Recommendation Report for Planning Permission

REF NO: LU/237/15/PL

LOCATION: The White Hart Public House
32 Surrey Street
Littlehampton

PROPOSAL: Removal of old front porch & installation of new front porch, replacement of glazing to 2 No. ground floor front bay windows, 5 No. first floor front Georgian sash windows & 2 No. second floor front dormer windows & installation of former railings to forecourt perimeter. This application affects the character & appearance of the Littlehampton River Road Conservation Area. (Resubmission following LU/306/14/PL.)

PROPOSED PLAN, FRONT AND SIDE ELEVATION
at: THE WHITE HART PUBLIC HOUSE,
32 SURREY STREET, LITTLEHAMPTON, WEST SUSSEX BN17 5BH

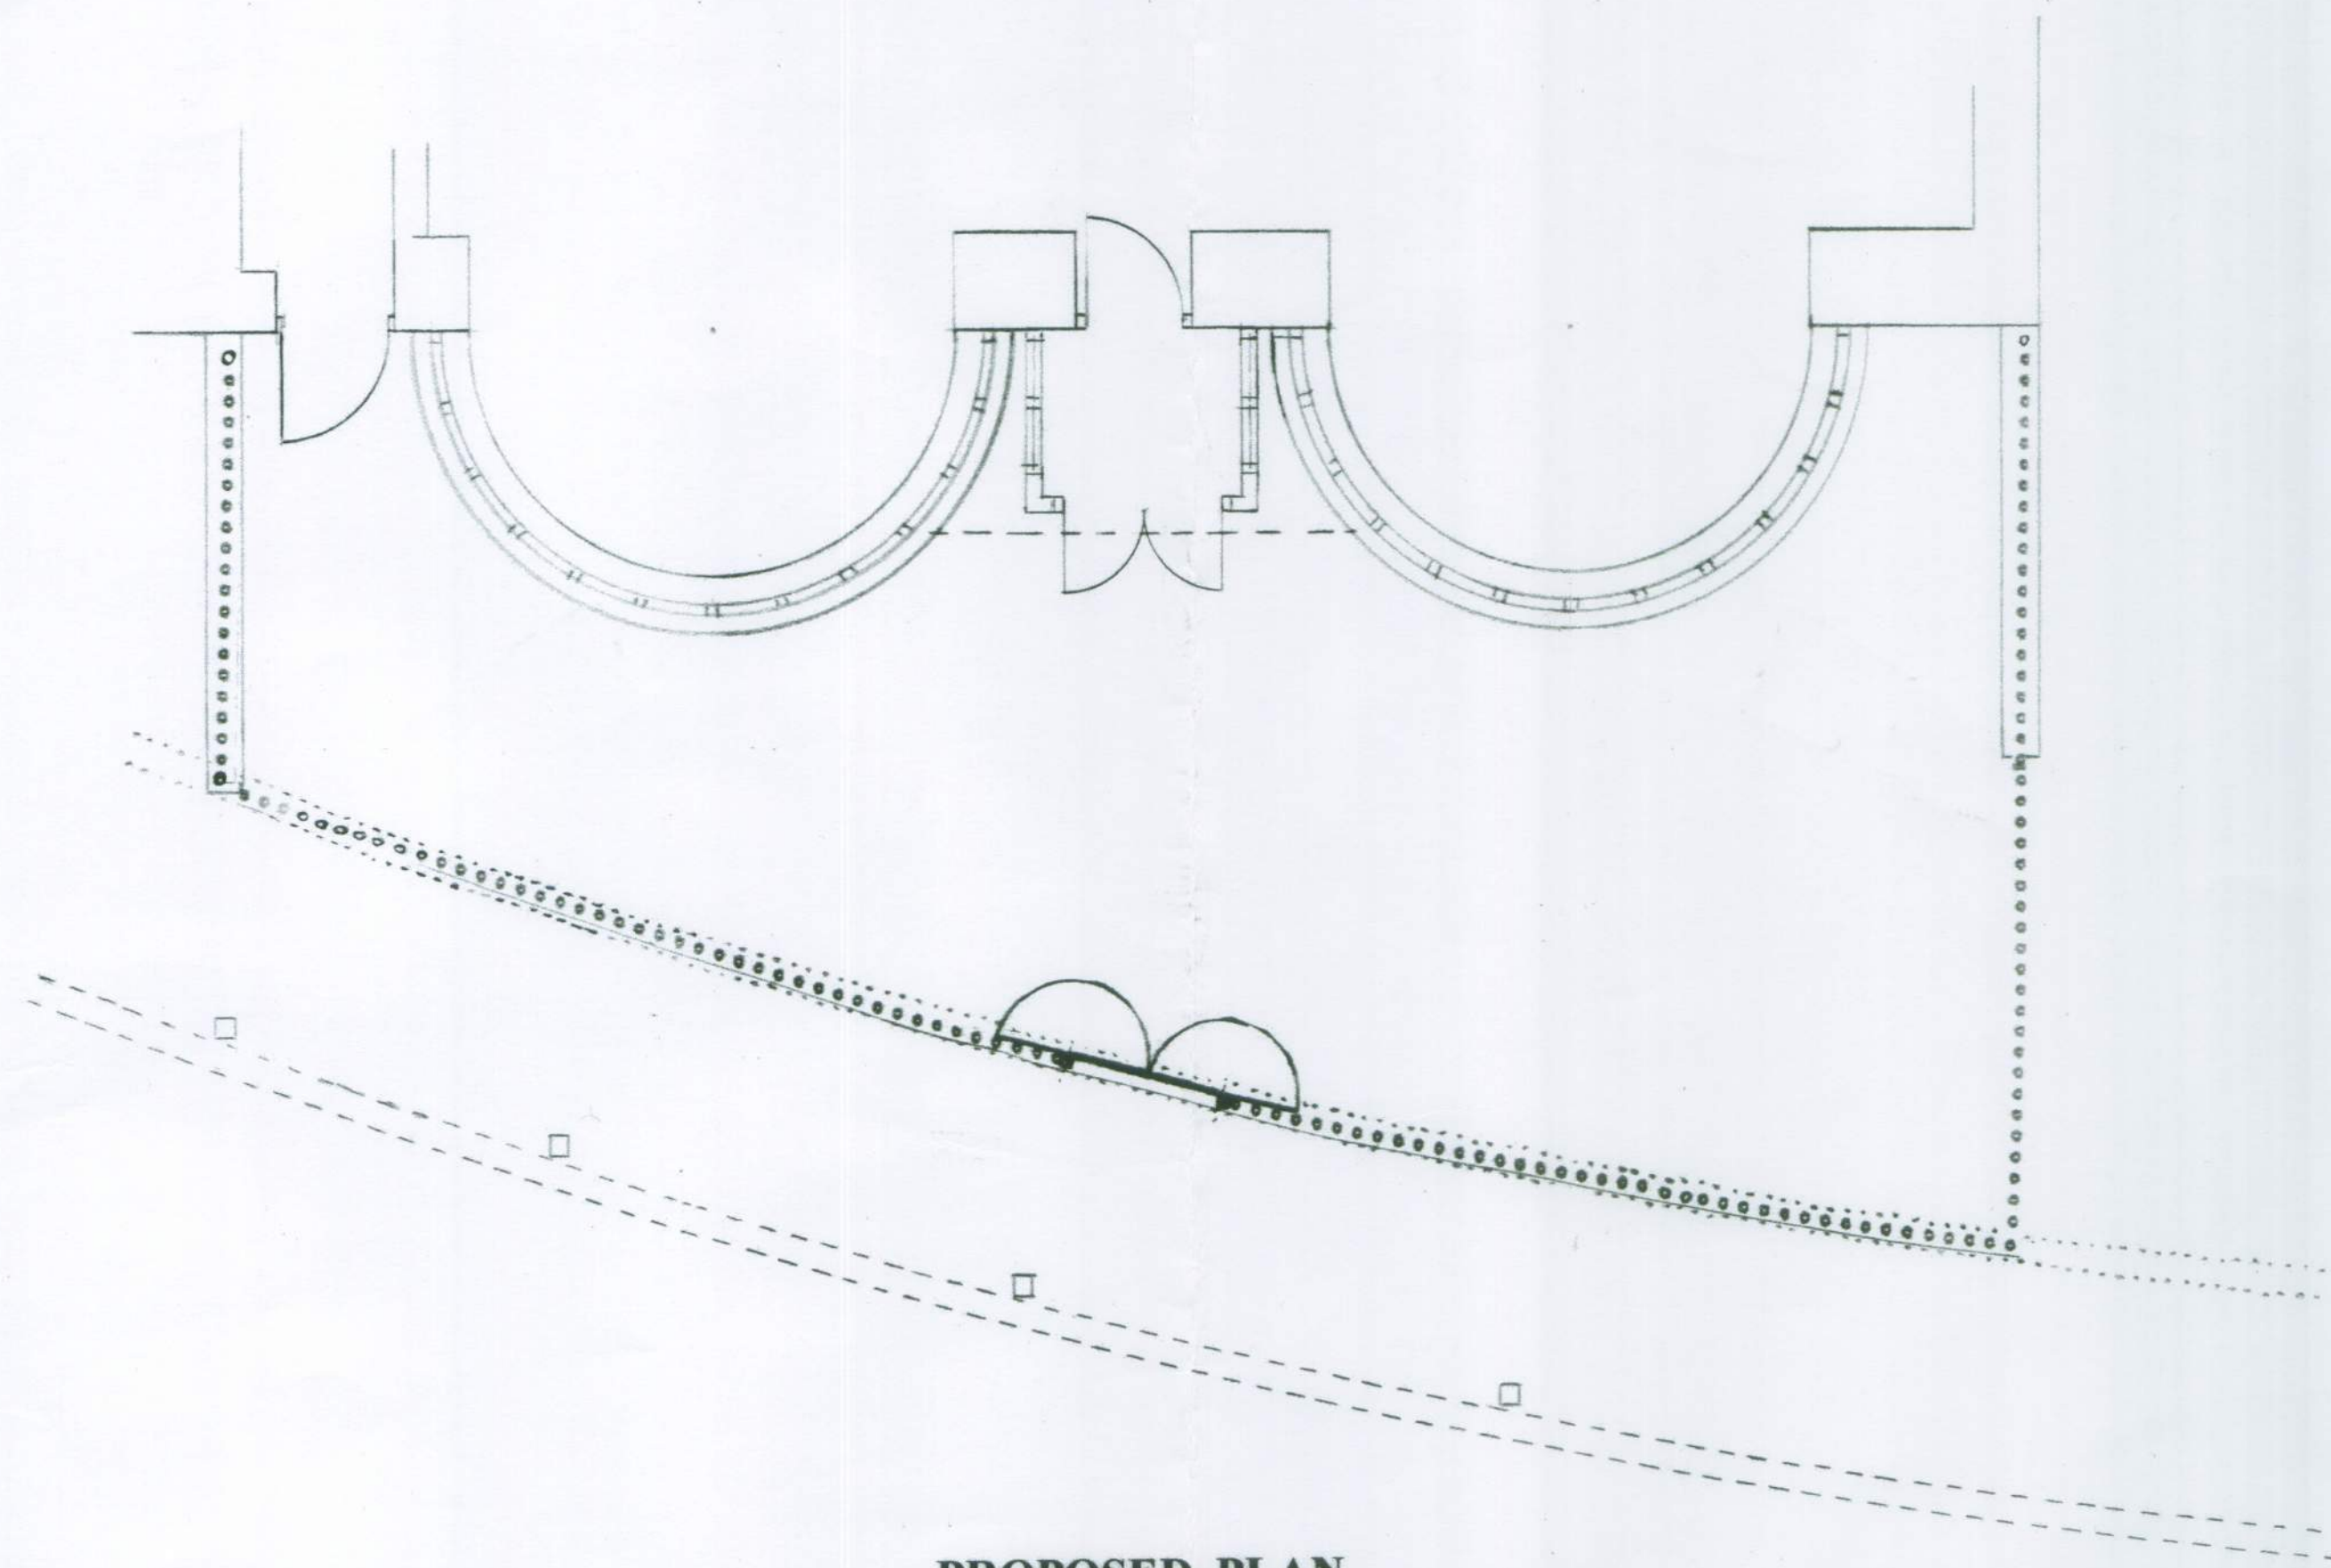
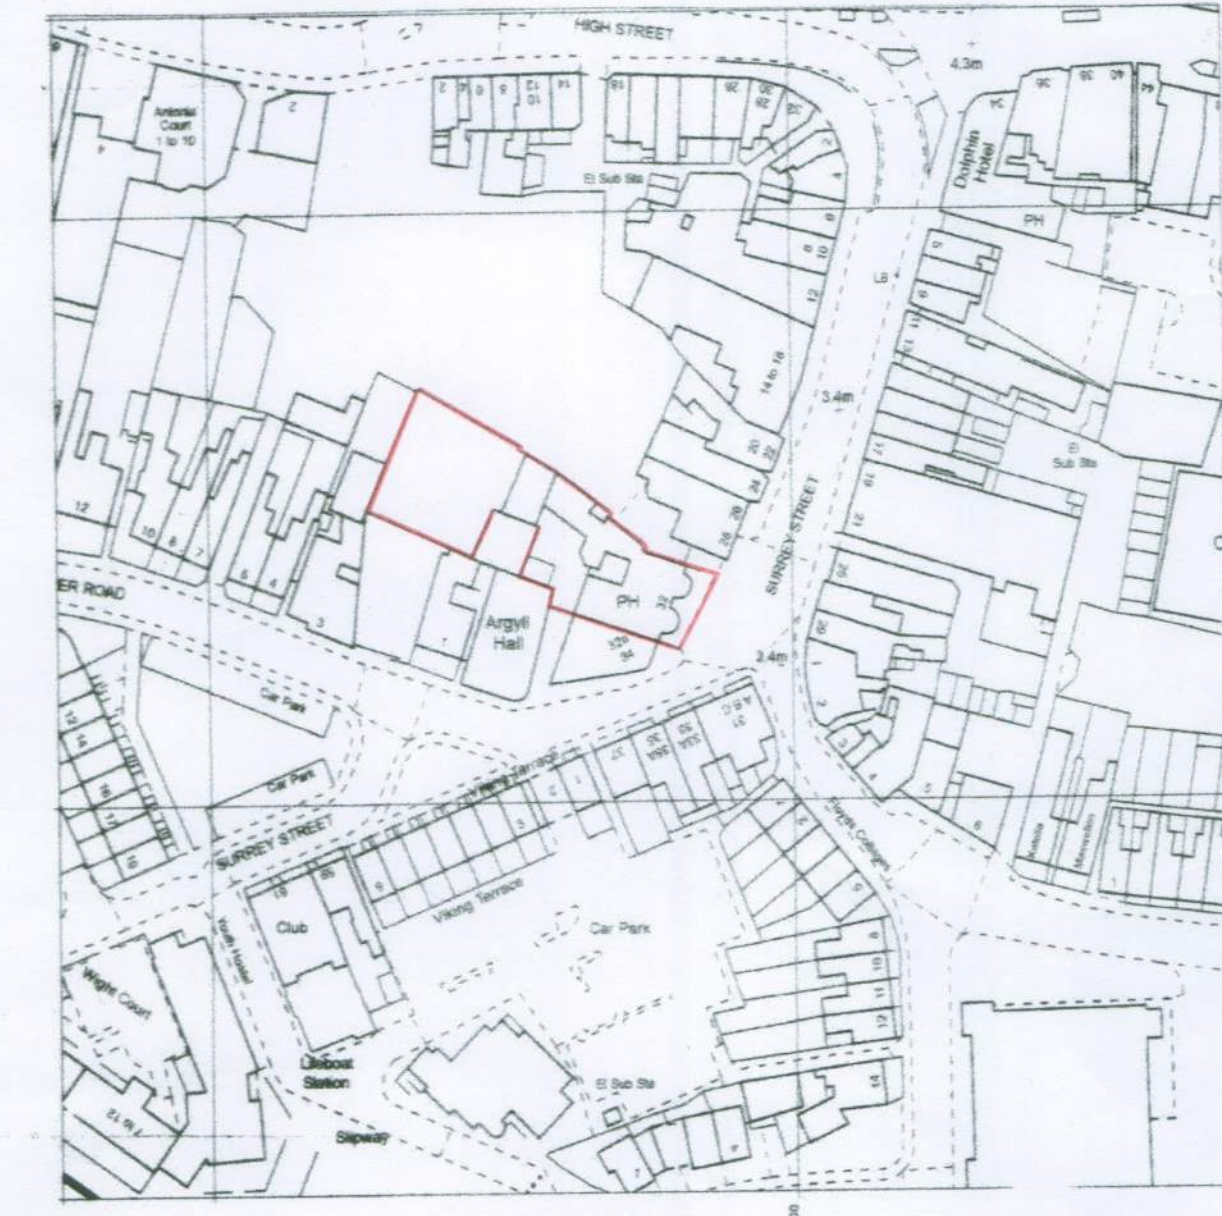
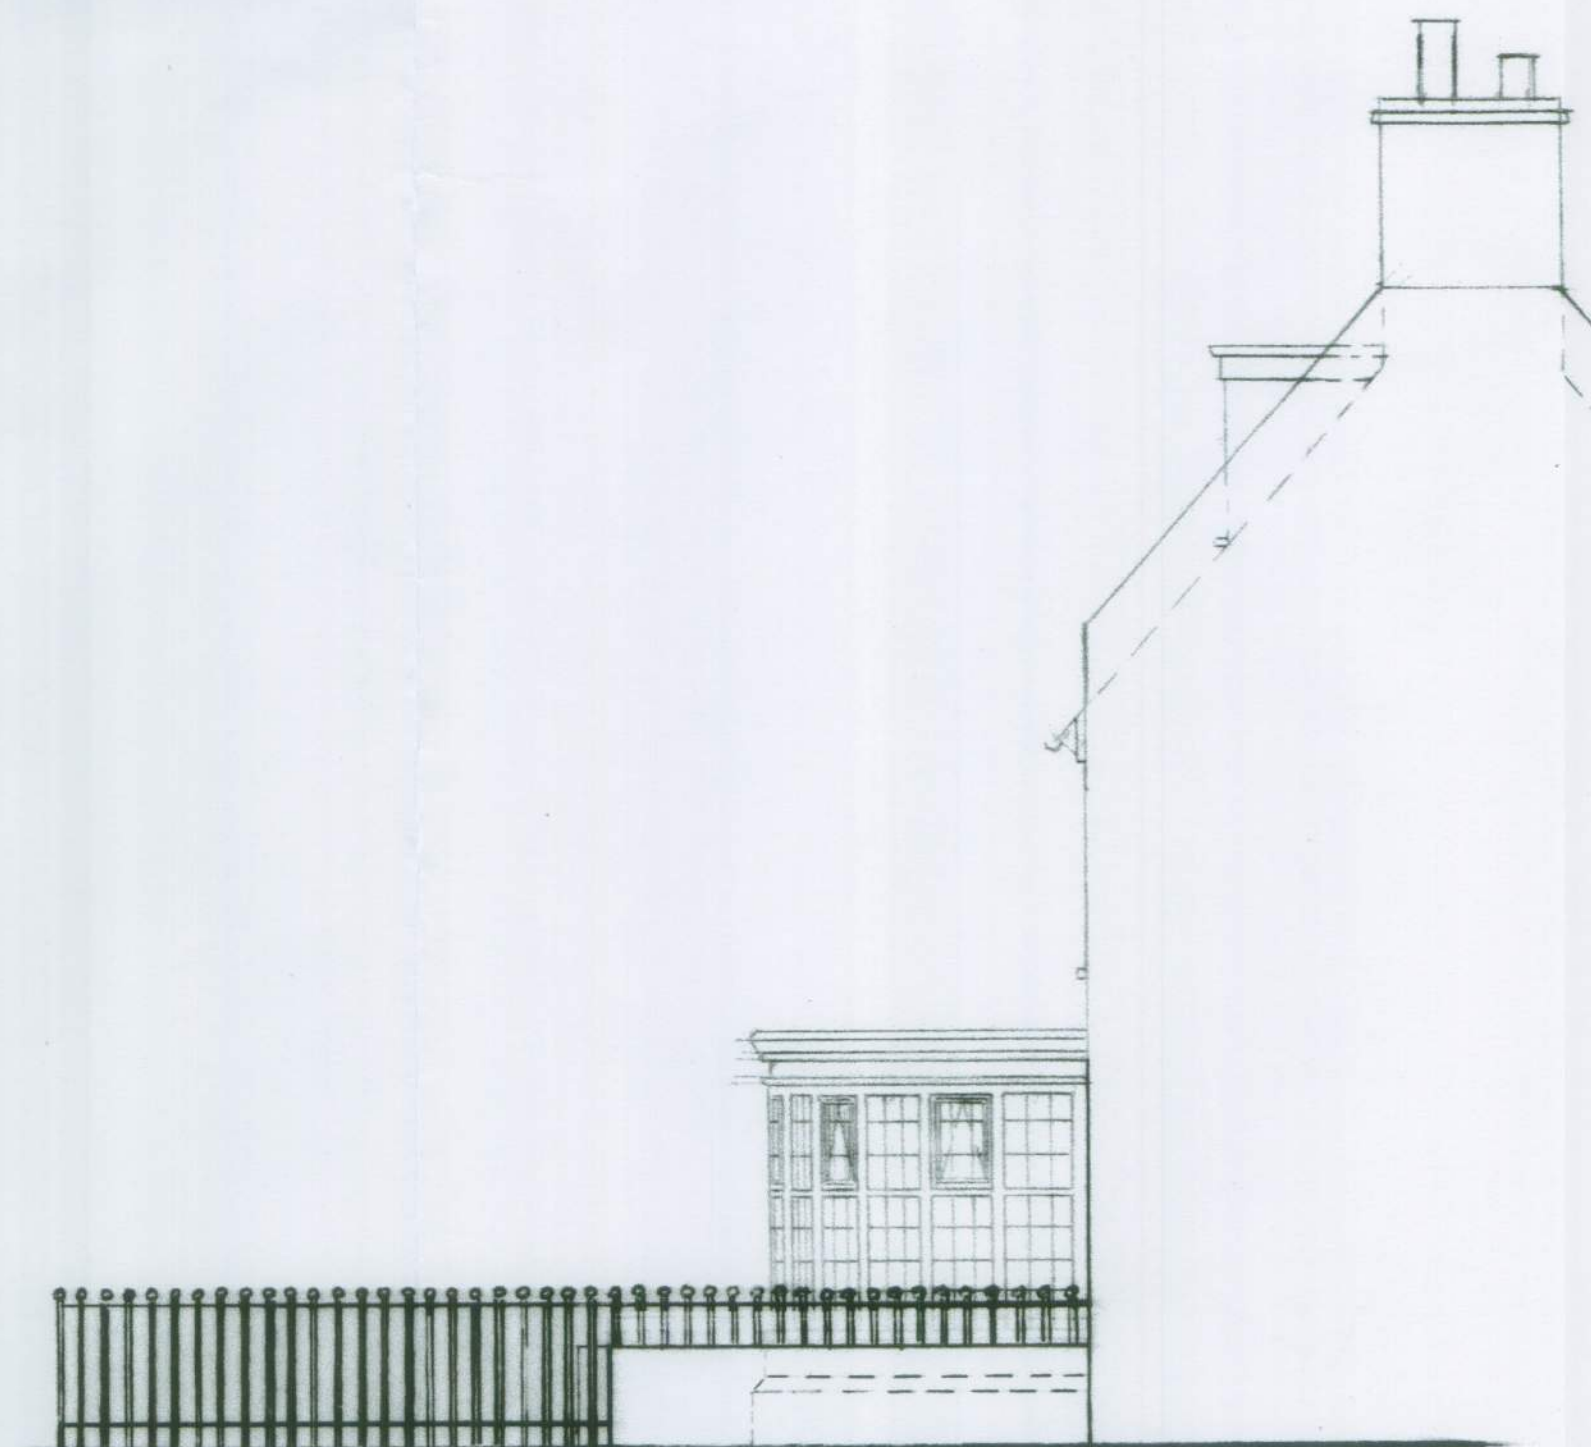
Conservation Area Advisory Committee - Windows should be refurbished and not replaced, repairing as much of the original timber and glass as possible. Comments re porch would like more detailed plans of porch to enable further comments to be made. Suggest an alternative approach would be to have an internal lobby and remove the existing porch with perhaps a small canopy.

Comments on railings - Objection- overpowering and out of keeping. Suggest sides only

This proposal also has three components. The replacement windows now proposed would match the existing in style, materials and design and there would therefore be no adverse impact on the appearance of the building in terms of its impact on visual amenity and the character of the area. However the application for Listed Building Consent has been refused in relation to the replacement windows in that their replacement, rather than repair, would adversely affect the historic fabric and character of the listed building.

The proposed changes to the porch would increase its size, but would centralise the appearance of the structure on the front elevation. The design of the porch has been amended and is now more in keeping with the appearance of the Listed Building and the appearance of the Conservation Area. It would be of limited dimensions and would not dominate the elevation. This element of the proposal would therefore also be acceptable in terms of its impact on the visual amenities of the locality and character of the area.

However, the railings are little altered from the previous refusal and remain unacceptable. The installation of railings to the forecourt area of the listed building would create a prominent and obtrusive means of enclosure in the street scene and adversely affect the open setting of the building. The extent of the area would not replicate that which historically existed at the site and would look out of place in this open area of street frontage. The railings would heighten the appearance of the building in the street scene and visually segregate it from its setting. Whilst

some form of enclosure may be acceptable the 13.5m length proposed would be overly dominant and would detract from the character and appearance of the Conservation Area where it would be viewed as an alien feature which would not preserve or enhance its historic setting.

- 1 By reason of the design, extent and position of the proposed railings they would damage the setting of a Grade 2 Listed Building and detract from the character and appearance of the Conservation Area by forming a prominent and obtrusive feature in the street scene in conflict with policies AREA2 and GEN7 of the Arun District Local Plan and with the National Planning Policy Framework.
- 2 **INFORMATIVE:** Statement pursuant to Article 35 of the Town and Country Planning (Development Management Procedure)(England) Order 2015. The Local Planning Authority has acted positively and proactively in determining this application by identifying
